**KIRKLEES METROPOLITAN COUNCIL
INVESTMENT & REGENERATION SERVICE**

DELEGATED DECISION TO DETERMINE PLANNING APPLICATIONS

Reference No: 2018/62/91386/W
Site Address: 14, Howard Avenue, Lindley, Huddersfield, HD3 3DJ
Description: Erection of two storey and single storey extensions
Recommending Officer: Sam Jackman

DECISION - REFUSED

DRG NO 1740 · 4B SCALE 1:50

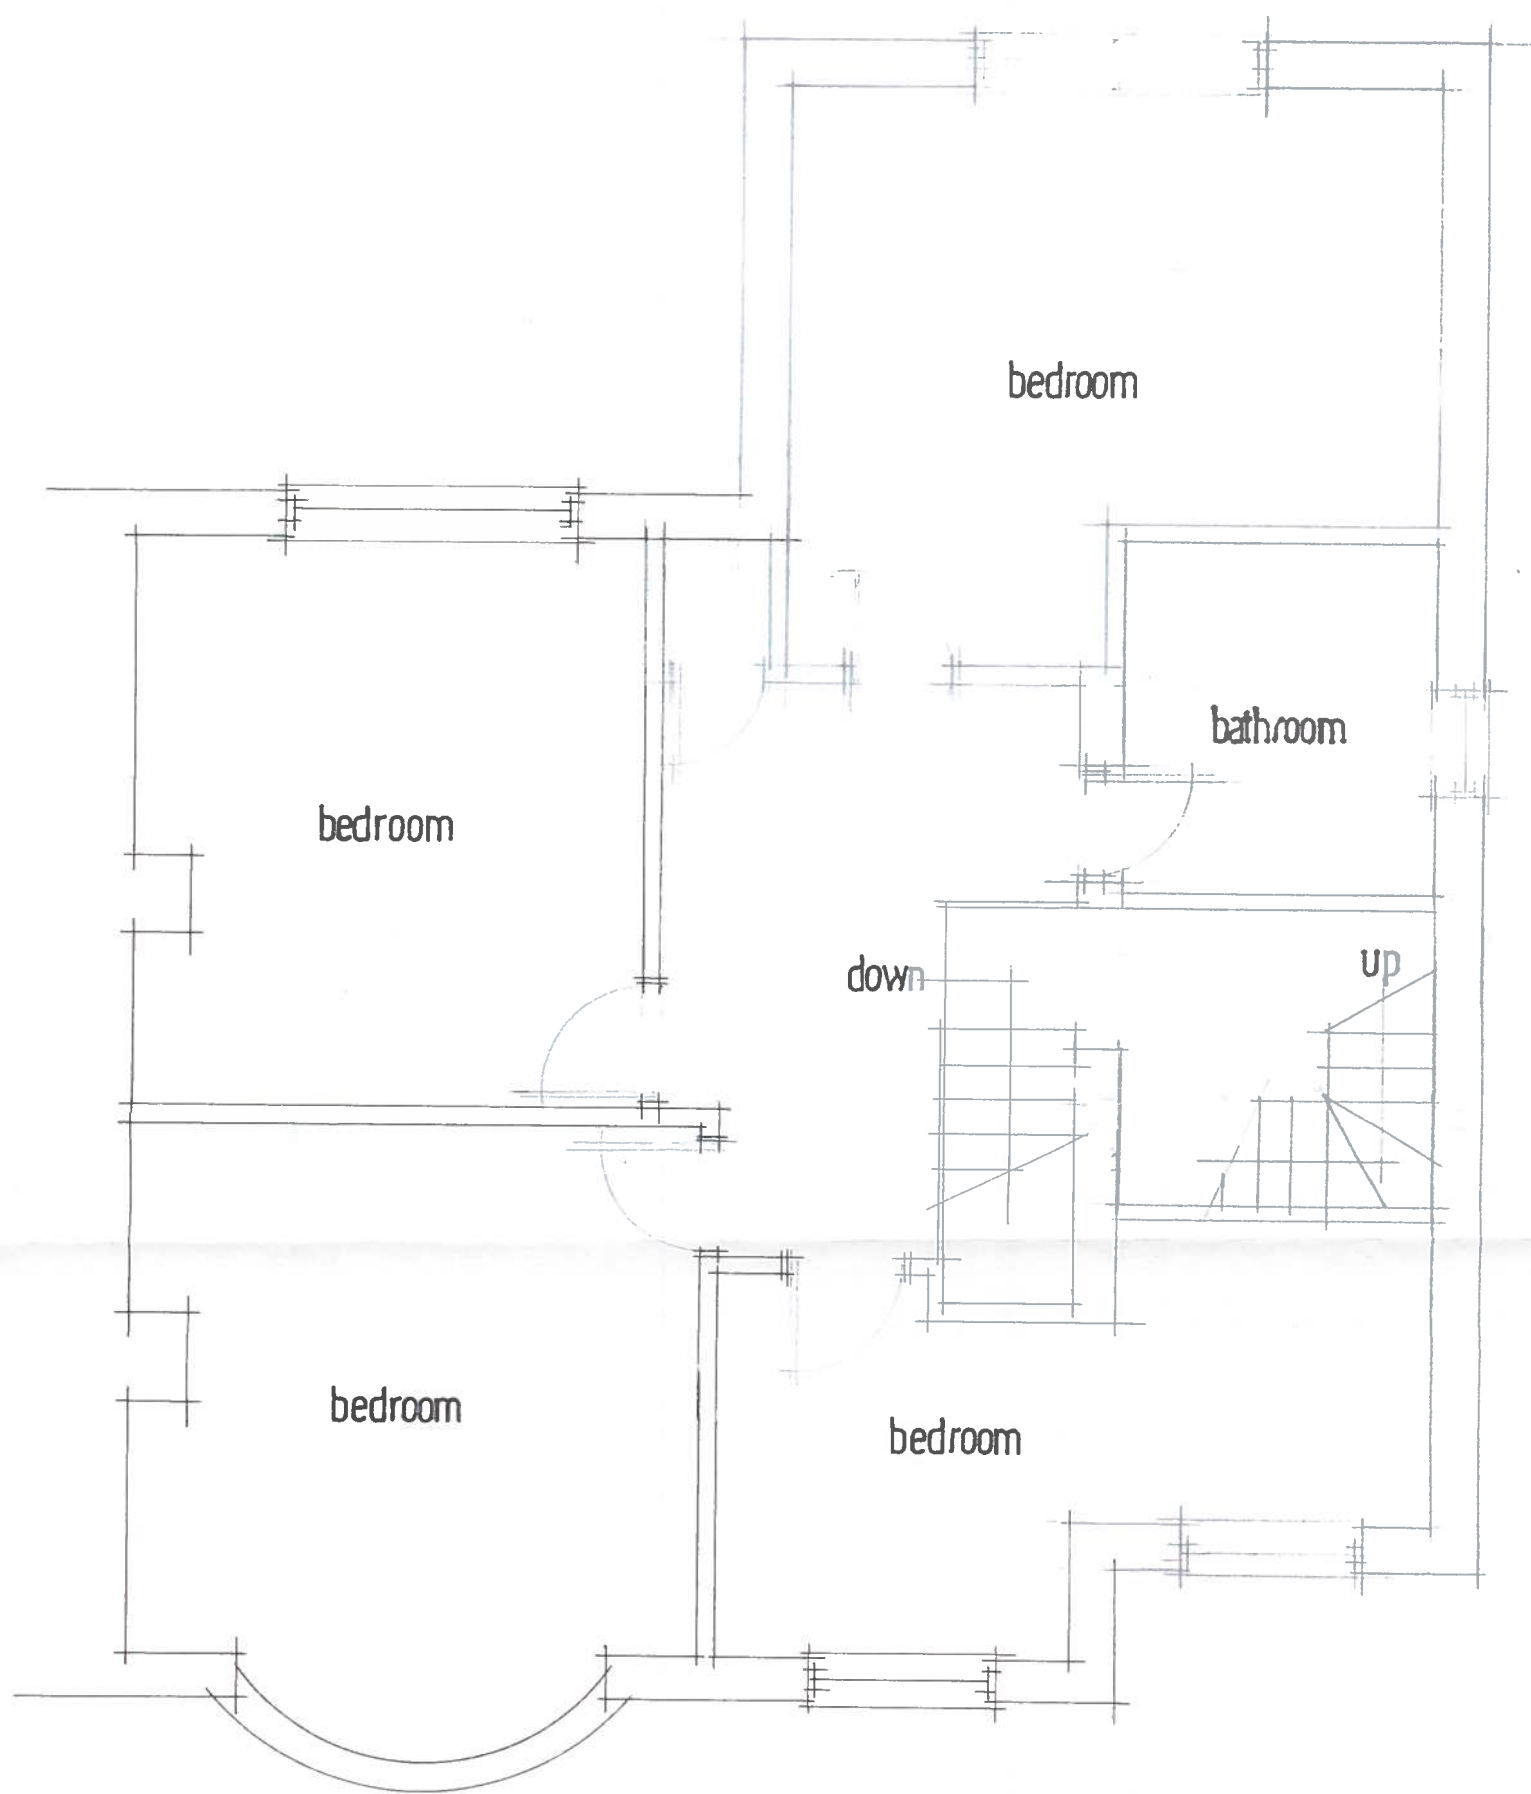
The proposed roof alterations would add additional bulk to the roof, furthermore the first floor rear extension which was added due to the loss of the loft conversion (in the previous scheme) has been retained, which would also add to the bulk of the extension, it is considered due to the size would create an overbearing effect to the detriment of the neighbouring property.

DRG NO 1740-8D SCALE 1:50

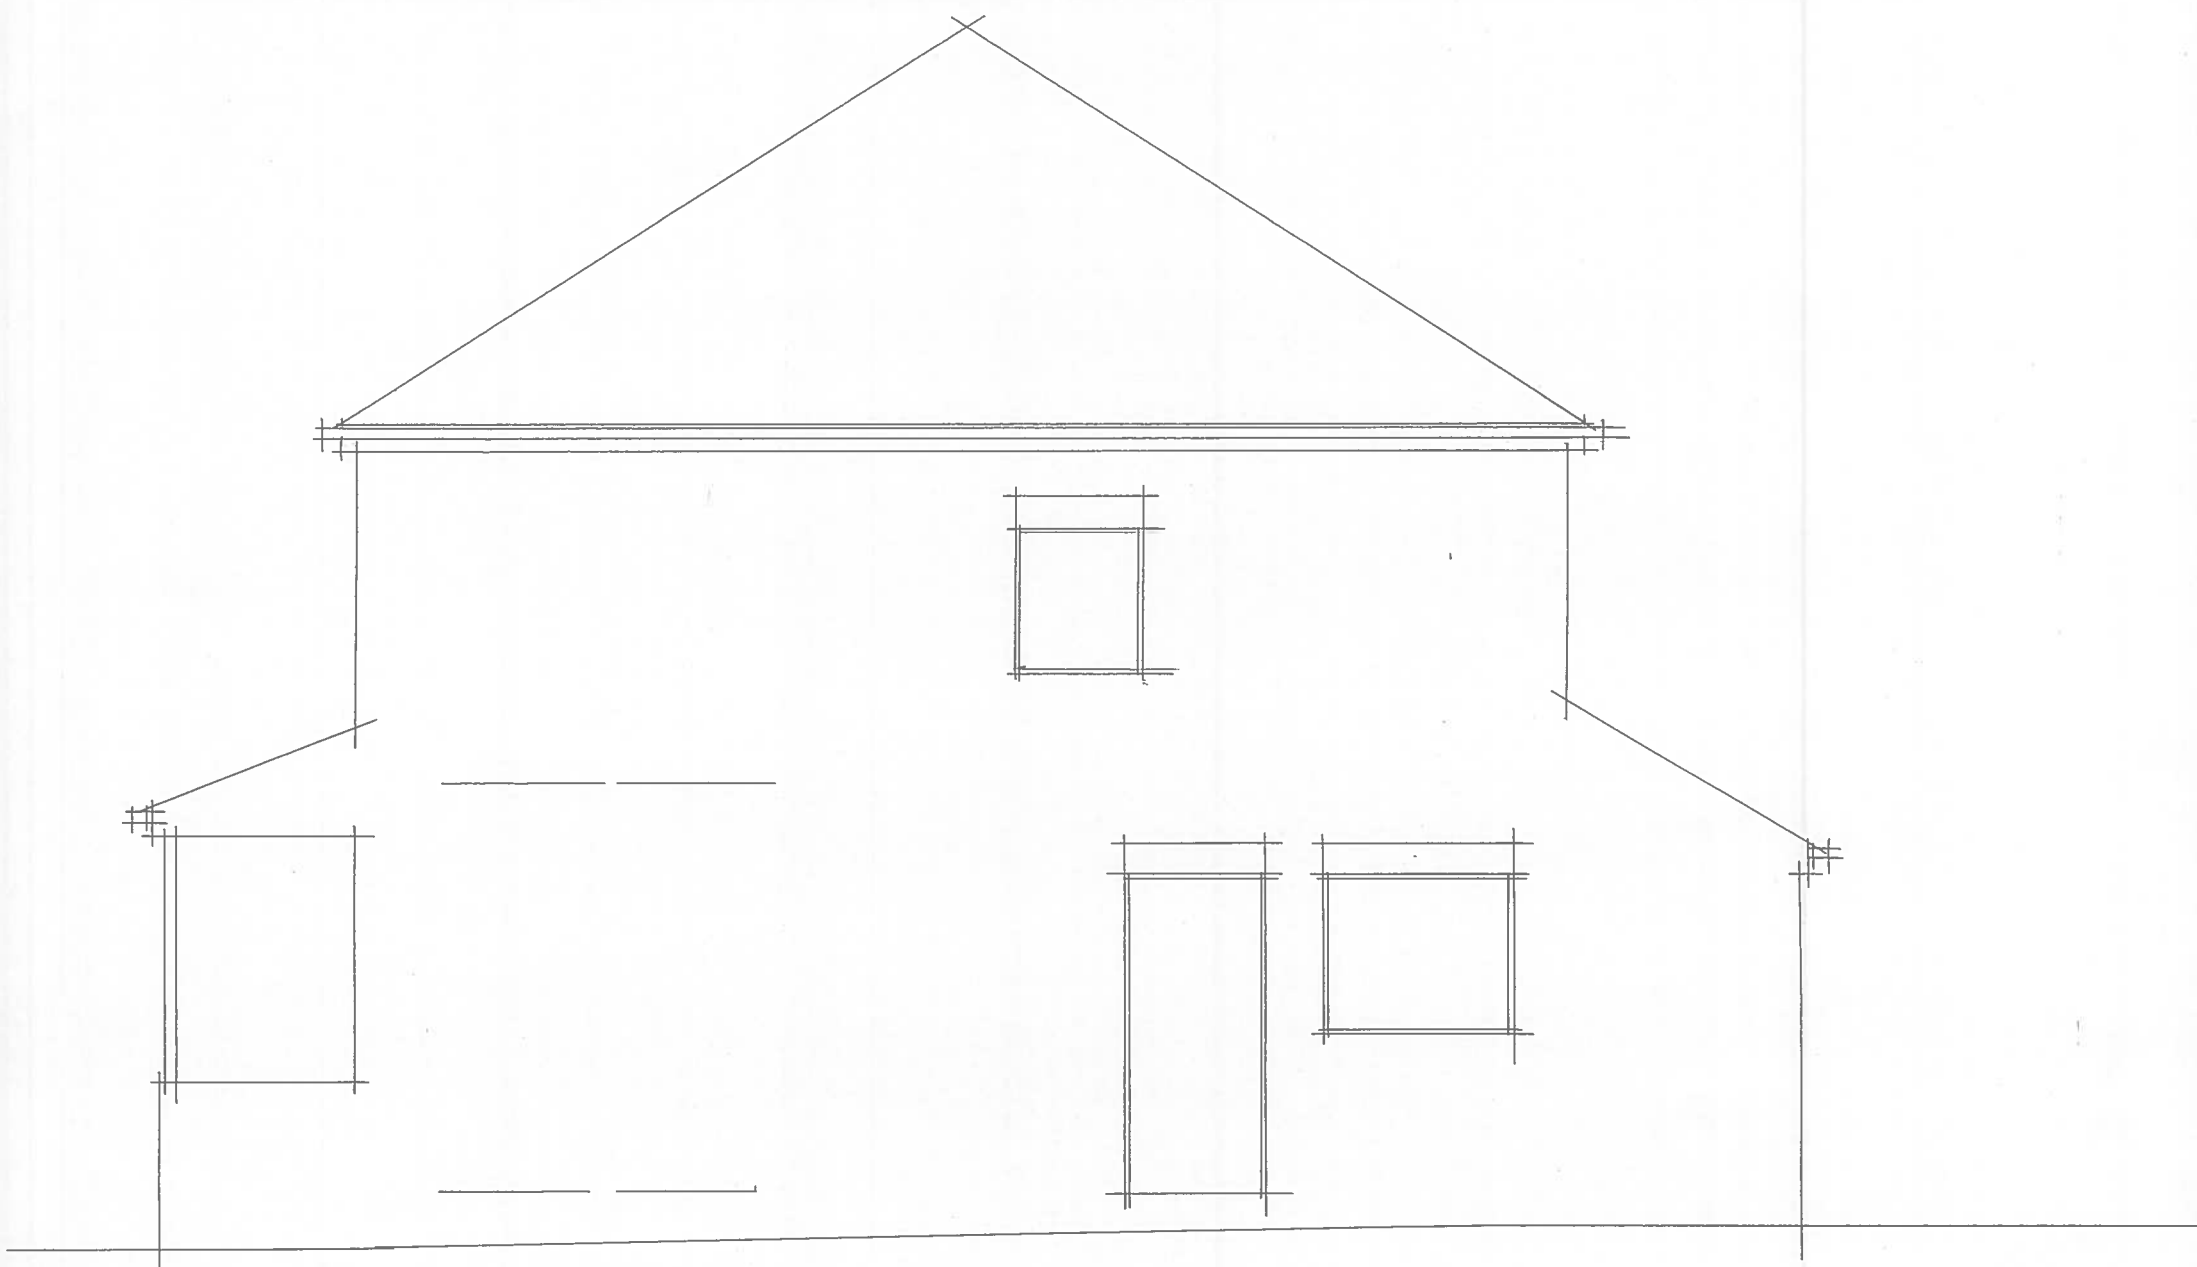
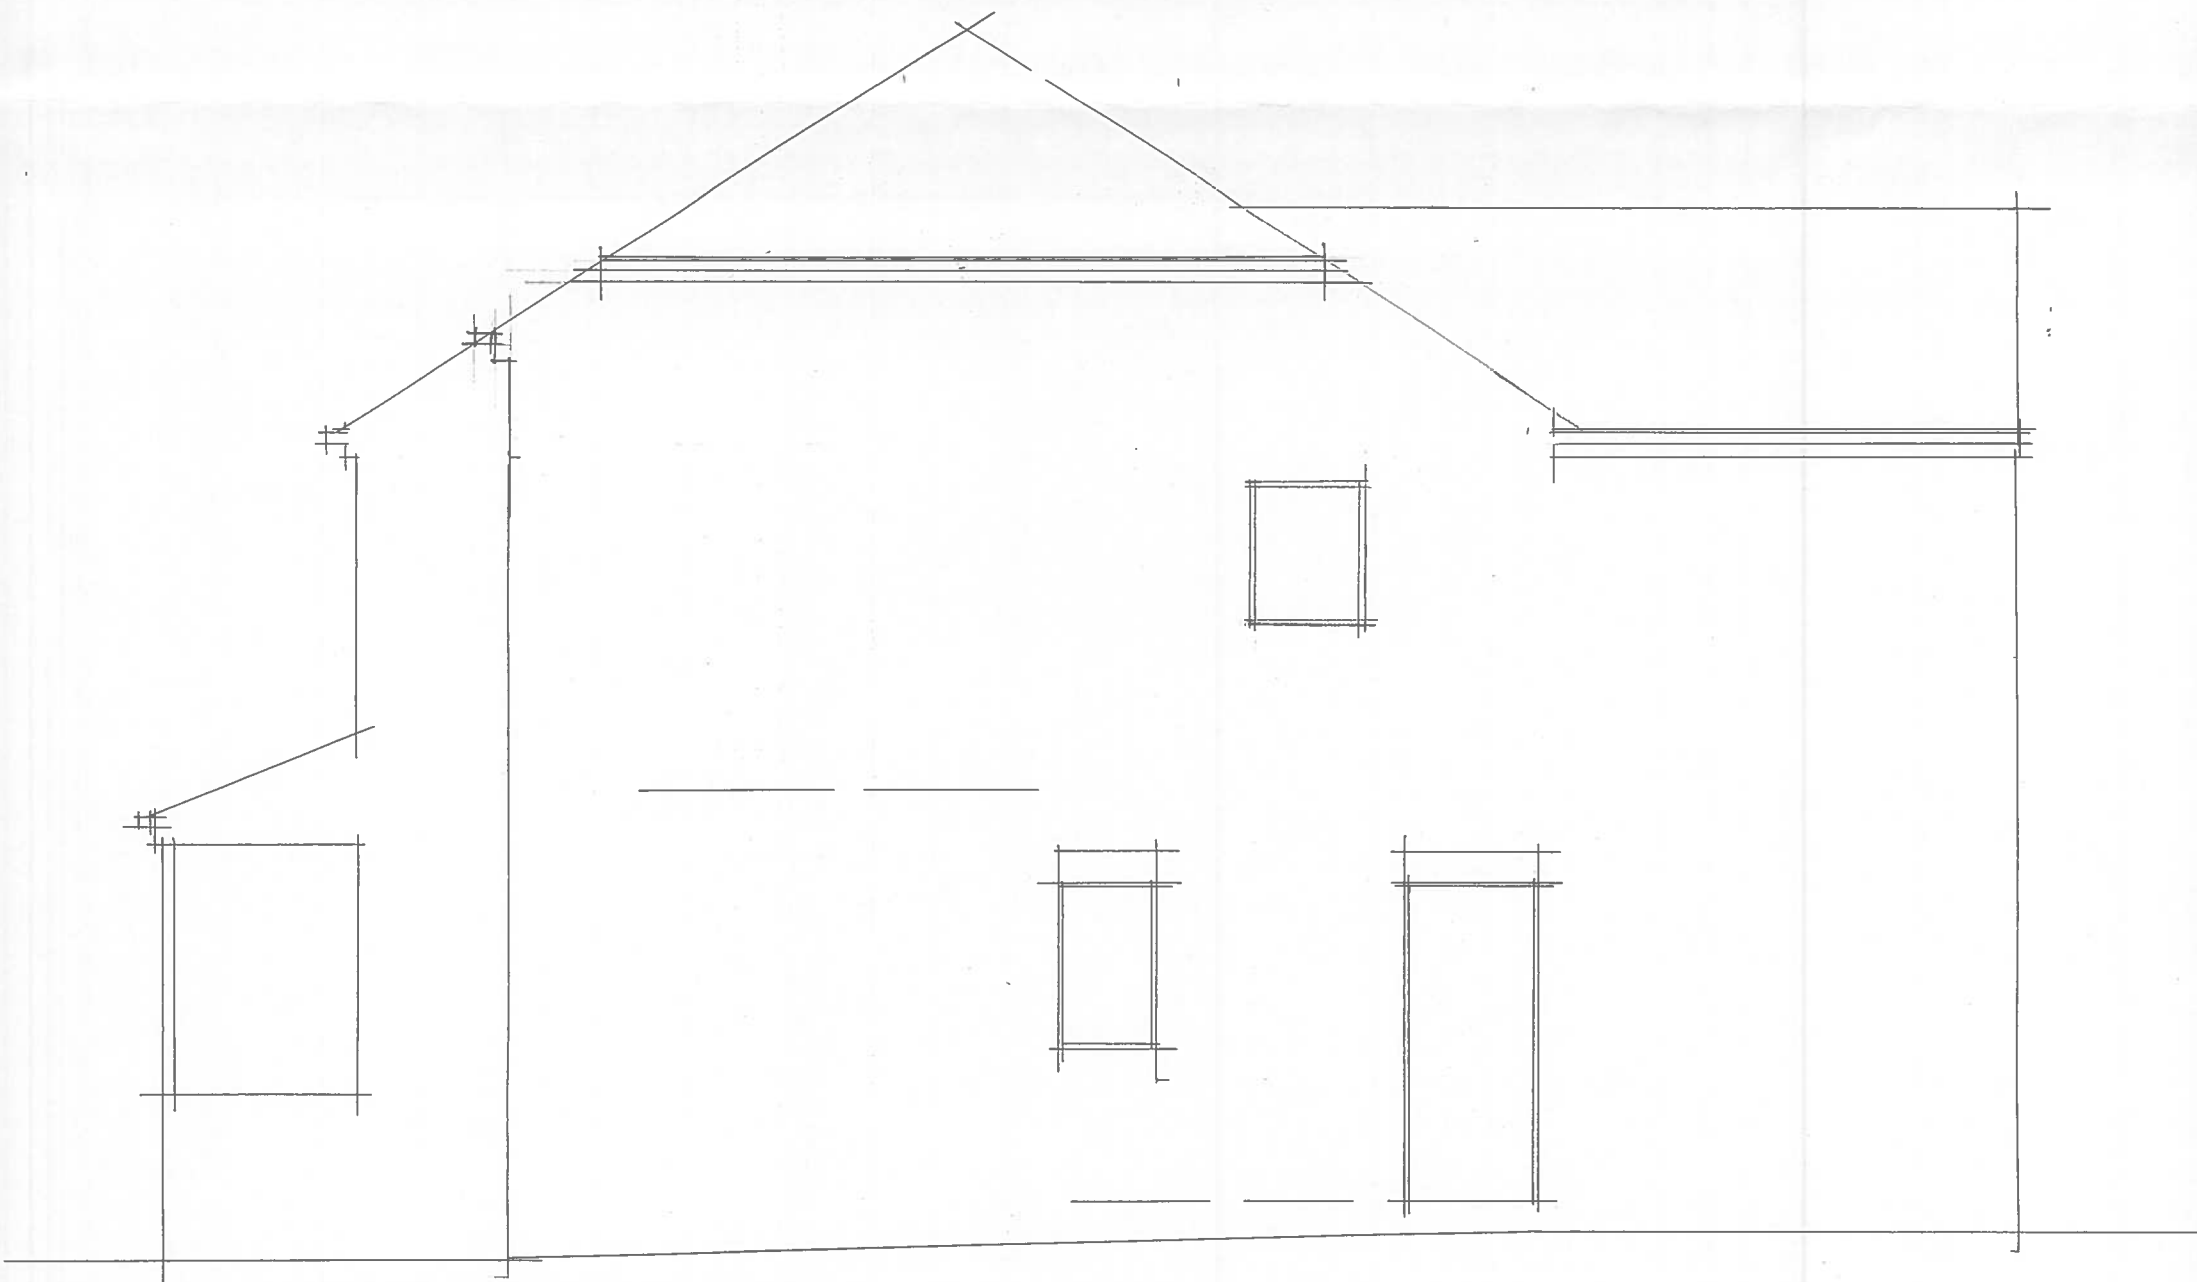
The side extension will be set back by 0.9m from the front elevation as approved, however where the roof was stepped down, the ridge now carries through into the altered roof and over the side extension which has a half hipped gabled roof. The previous application incorporated a new gable to the side extension which was deleted through negotiations with the agent.

- Unbalance the appearance of the pair of semi-detached properties.
- Would dominate the appearance of the property and its neighbour, given its relationship with them, due to the host property being built forward of the neighbour's property No 12a.
- Finally due to the host property being forward of No 12a, the gable would be very prominent within the street scene when travelling along Howard Avenue from the North even with the set back of 0.9m.

The concerns raised previously still stand for the design of the half hipped gable now proposed. Whilst the current proposal is slightly smaller in scale than the scheme previously proposed and amended under application 2017/92609 the scheme of the current proposal would still carry the ridge of the extension through over the side extension which is considered to represent an incongruous feature within the street scene and the character of the wider locality.

The set back of 1 metre helps to reduce concerns of overshadowing to adjacent properties, although the raising the gable and raising the eaves on the side elevation would add a degree of overshadowing to the front elevation of no. 12A.

1.The proposed development, by reason of the roof design of the two storey side extension, would appear incongruous in relation to the host building and would unbalance the symmetry of the pair of semi-detached properties of which it forms part. This would be detrimental to visual amenity, including that of the wider street scene. the wider street its relationship with the adjoining no. the street scene and would be detrimental to the visual amenities of the area and would therefore be contrary to Policies BE1 (ii), BE2 (i) and D2 (vi) & (vii) of the Kirklees Unitary Development Plan and Policy PLP24 (c) of the Kirklees Publication Draft Local Plan and advice in Chapter 12 of the National Planning Policy Framework.

2. The proposed development would result in a significant overbearing impact on the occupants of Nos 12A Howard Avenue due to the scale and design of the roof of the two-storey side extension. The proposal would not accord with Policy D2(v) of the Kirklees Unitary Development Plan, Policy PLP24 (b) of the Kirklees Publication Draft Local Plan or paragraph 127 (f) of the National Planning Policy Framework which promotes health and well-being with a high standard of amenity for existing users of land.
